Please ask for: Nicola Moore
Email: nicola.moore@arun.gov.uk
Telephone: Ext 37944
Our Ref: A/268/21/PL
Your Ref:
Date: 11th January 2022

Application for Planning Permission

Development: Proposed car showroom and workshop with forecourt. This application is in CIL Zone (zero rated) as other development.
Location: Land East Of Roundstone Lane Angmering

Site Context Elevation

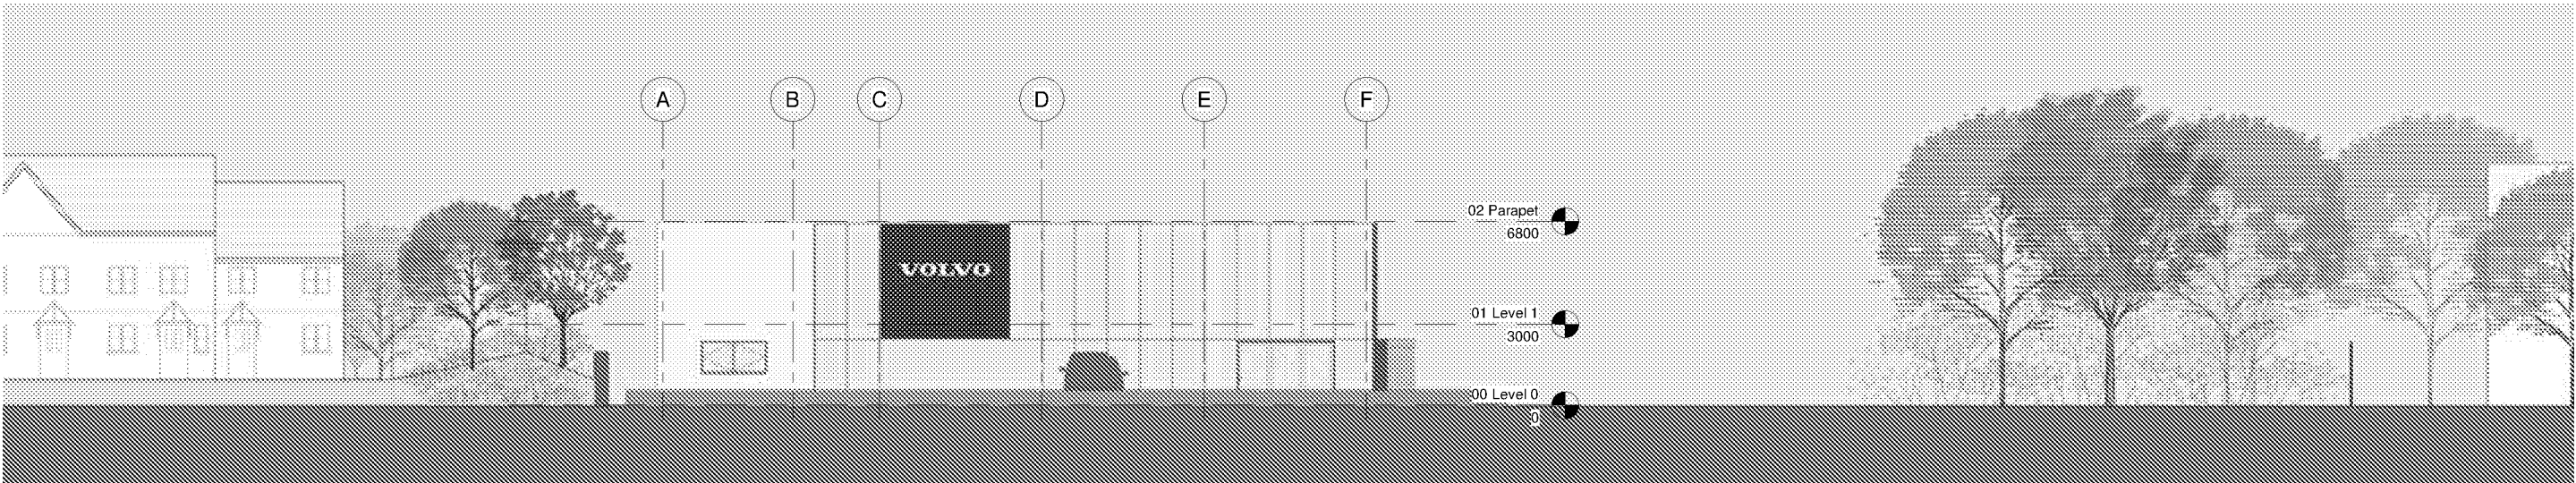
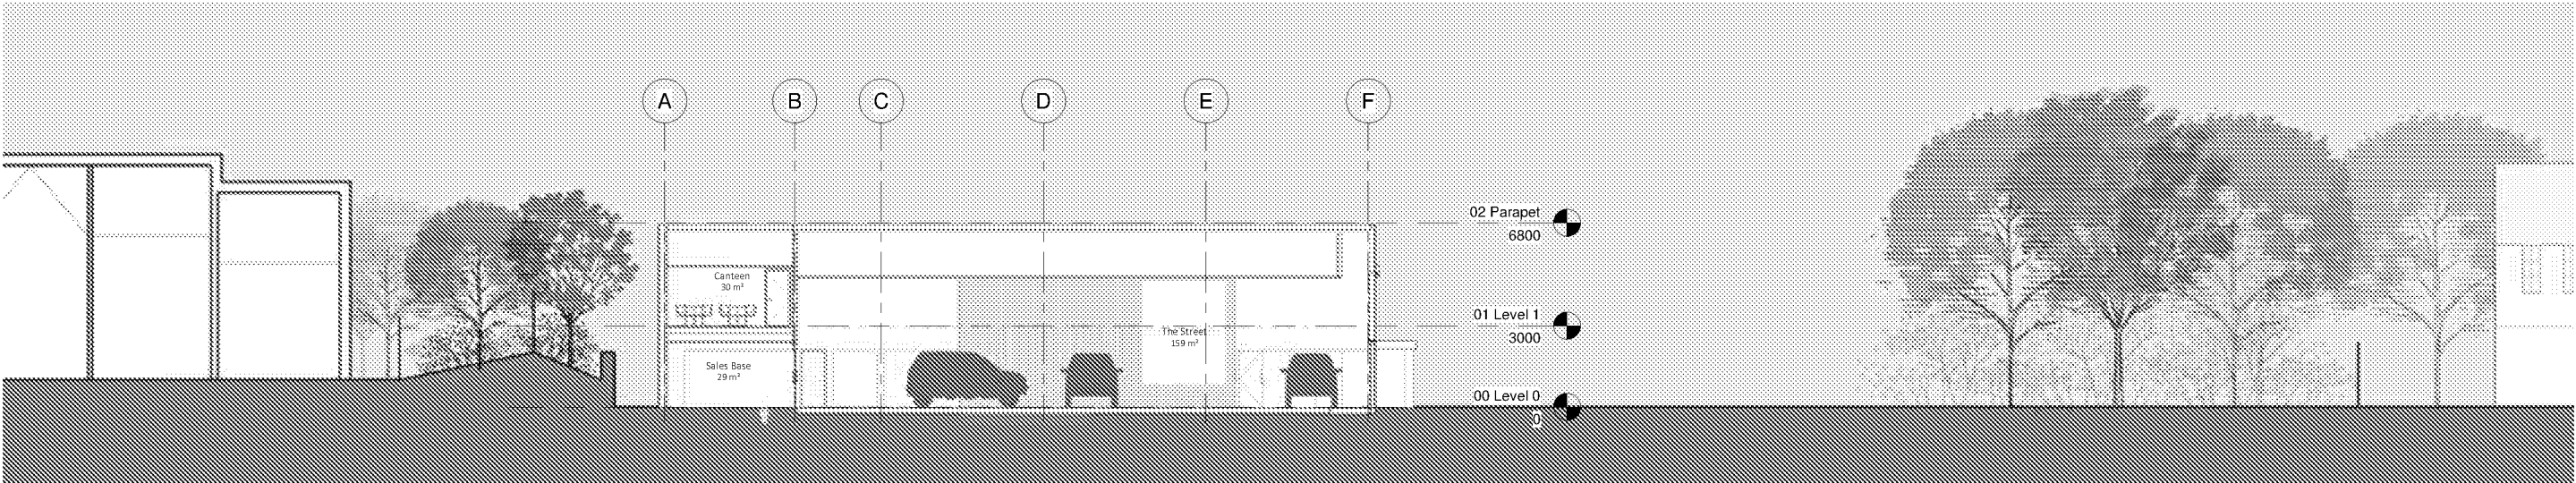
We are unable to scale plans at 1:125, please resubmit the Proposed Site Context Sections and Elevations at a scale of 1:100 or 1:50.

1 - Proposed Roof GA Plan
1 : 100

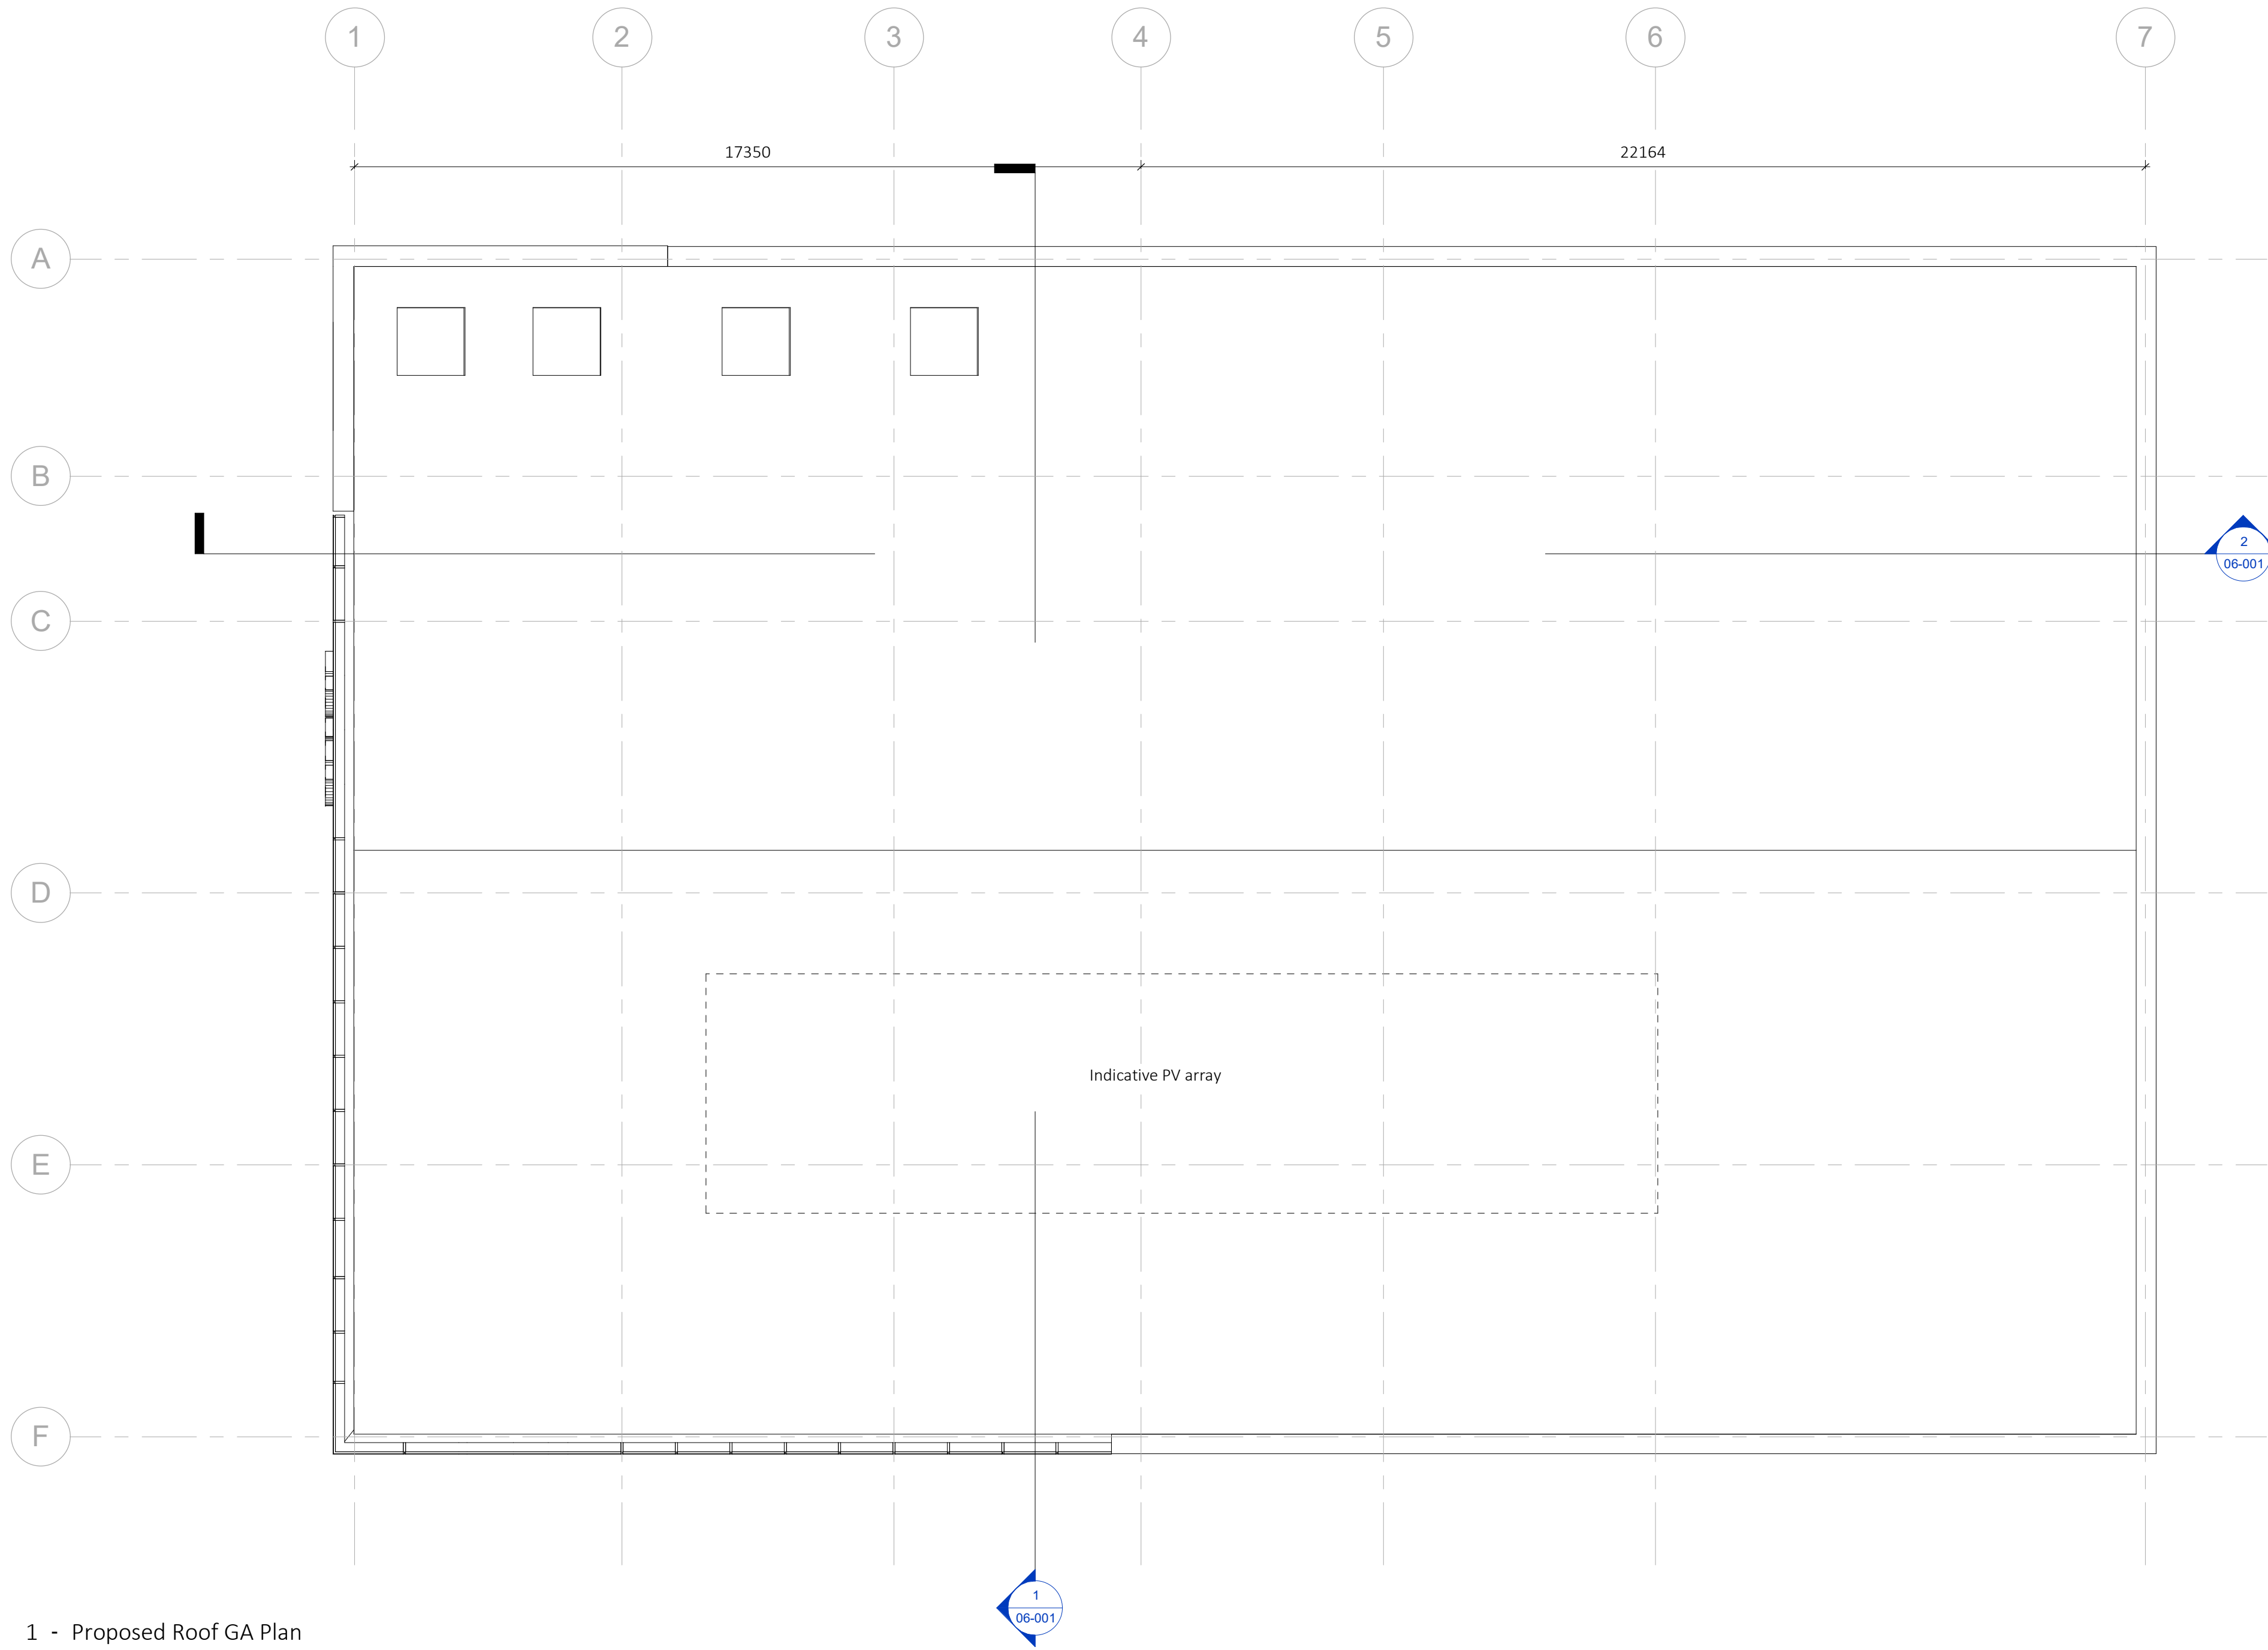
Roof GA Plan Dwg No 3661-SRA-XX-L2-D-A-04-201 has been submitted, however Dwg no 3661-SRA-XX-L2-D-A-04-201-P02 is listed on the Planning Statement. Please clarify the correct drawing and re submit accordingly.

1 - Proposed South Elevation GA
1 : 100

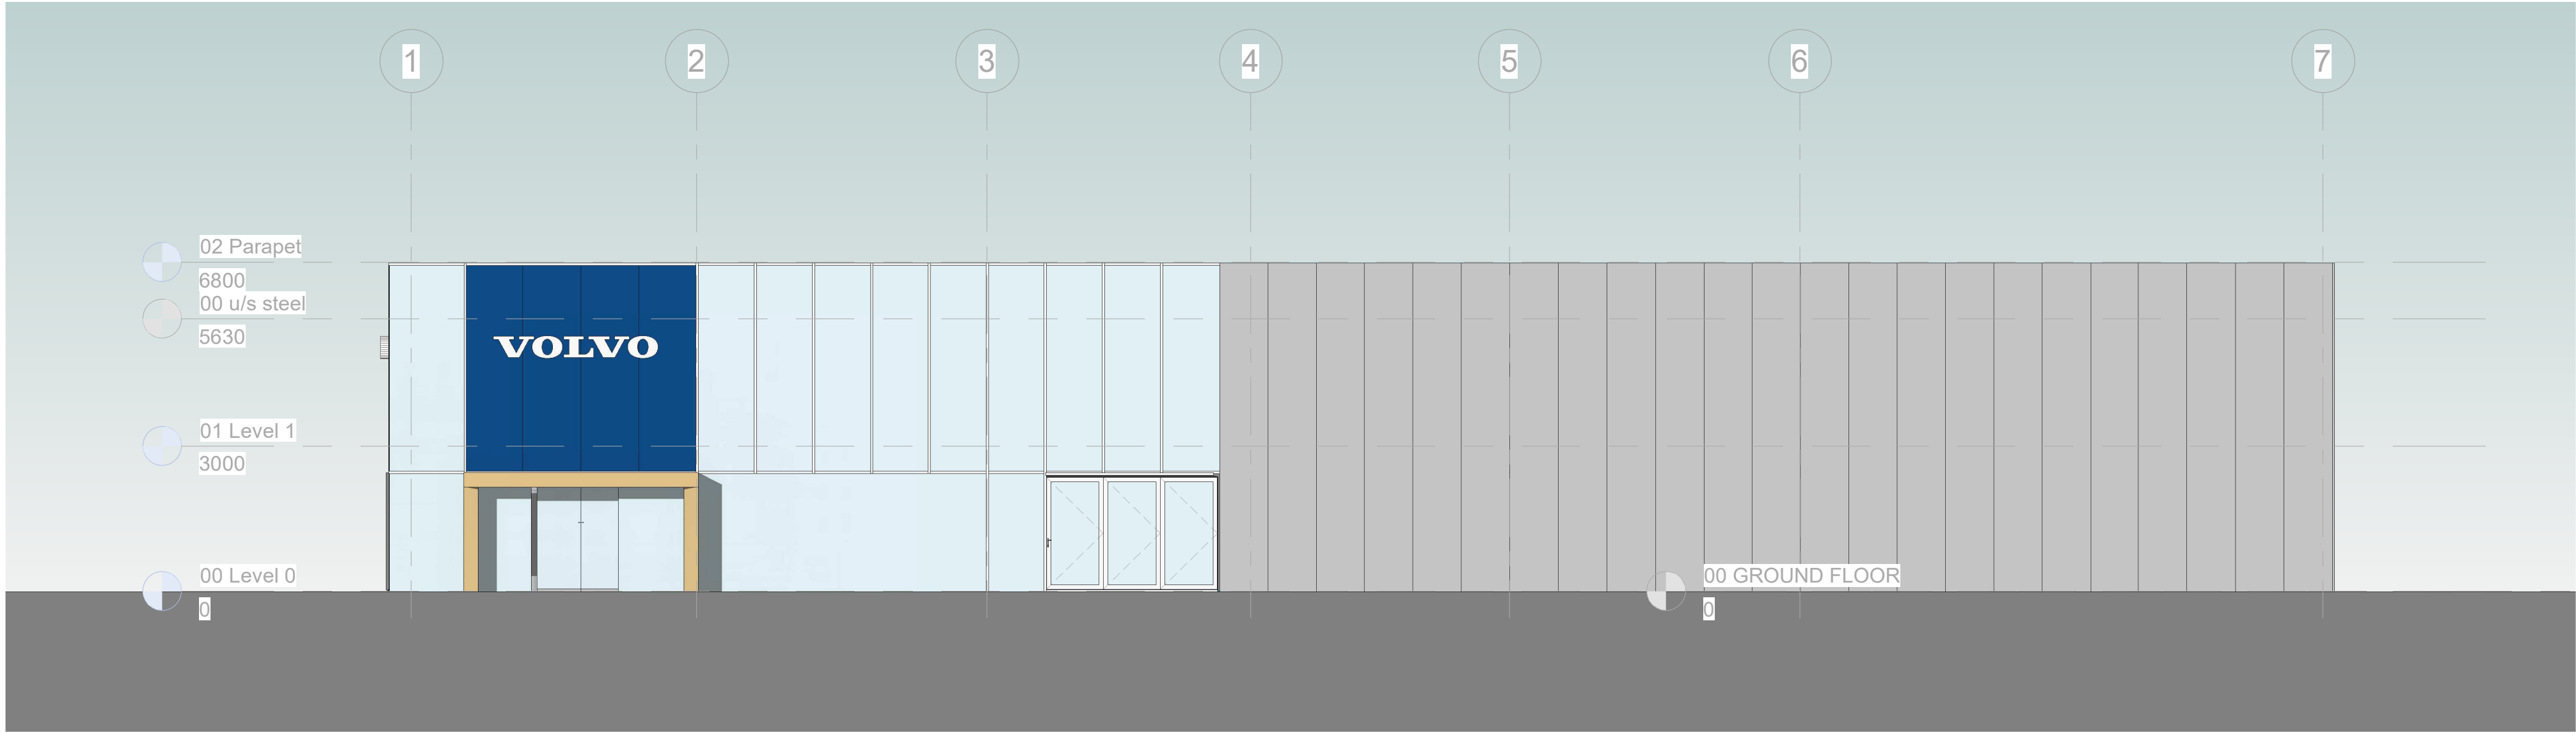
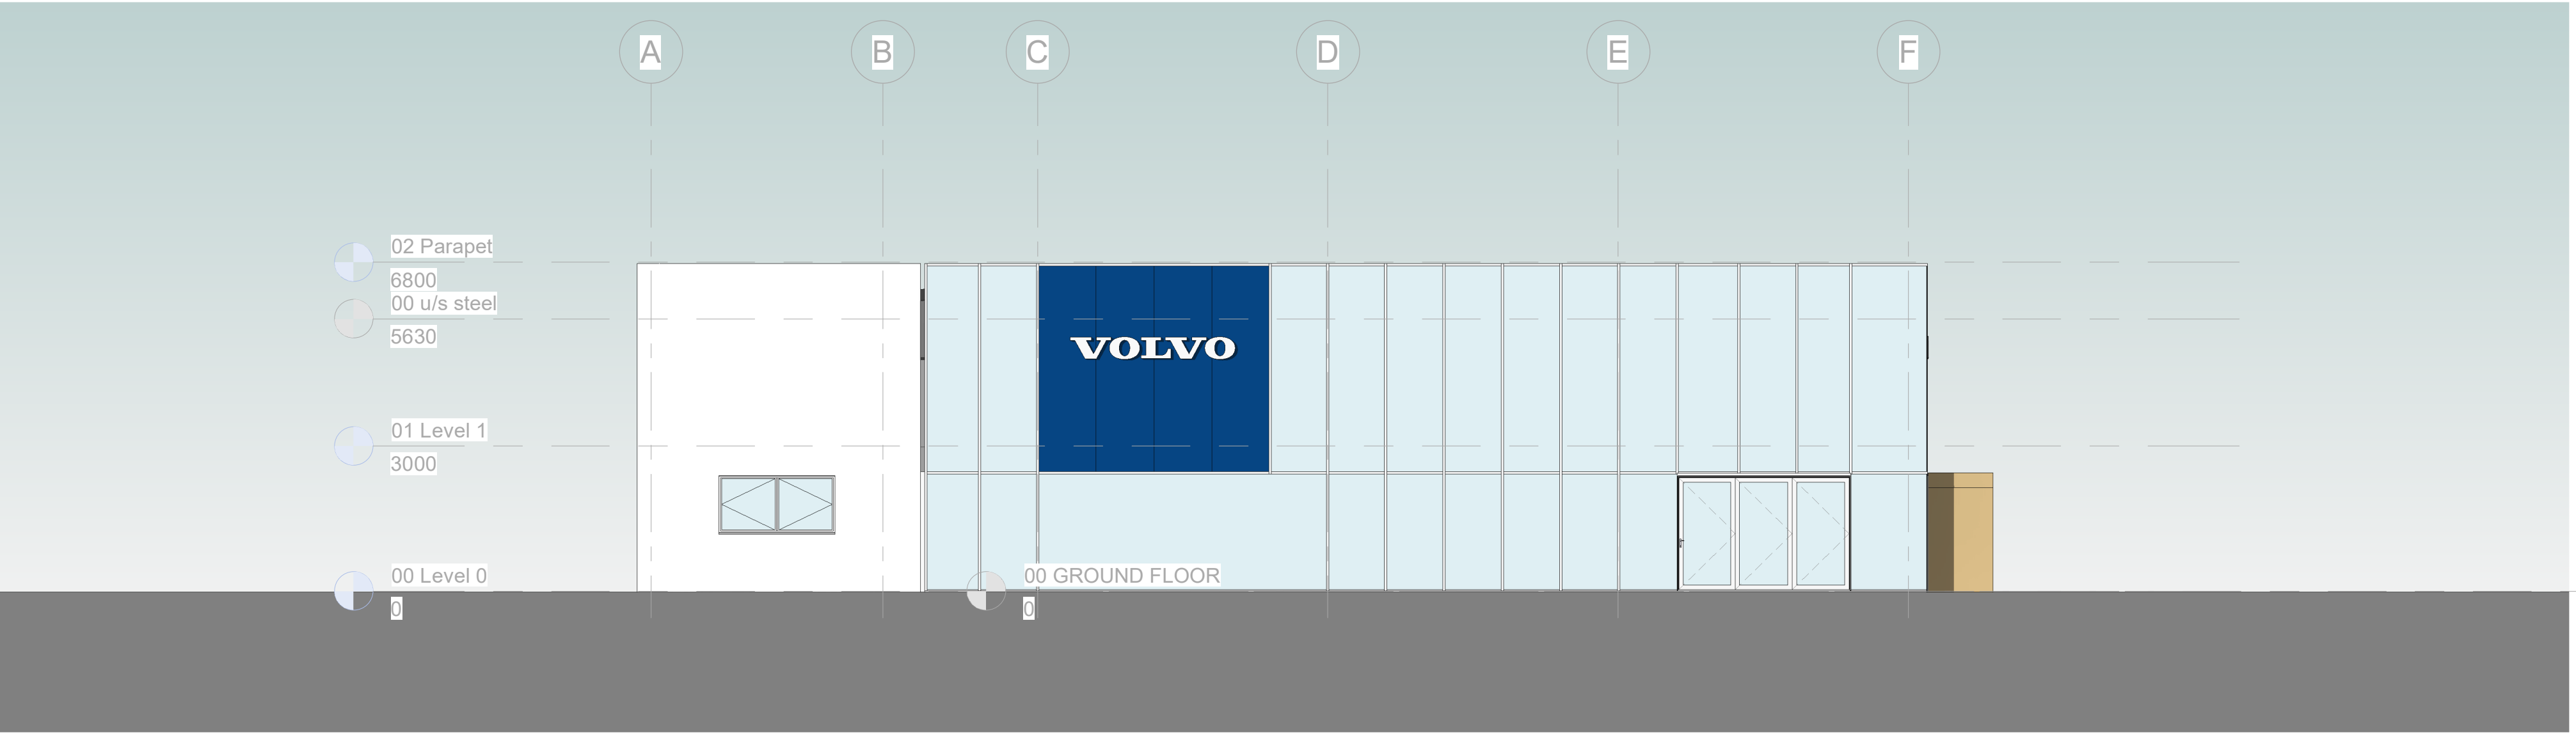
The scale bar on the Proposed South & West Elevations is 5m but measures 10m. Please check the measurements, amend accordingly and re submit.
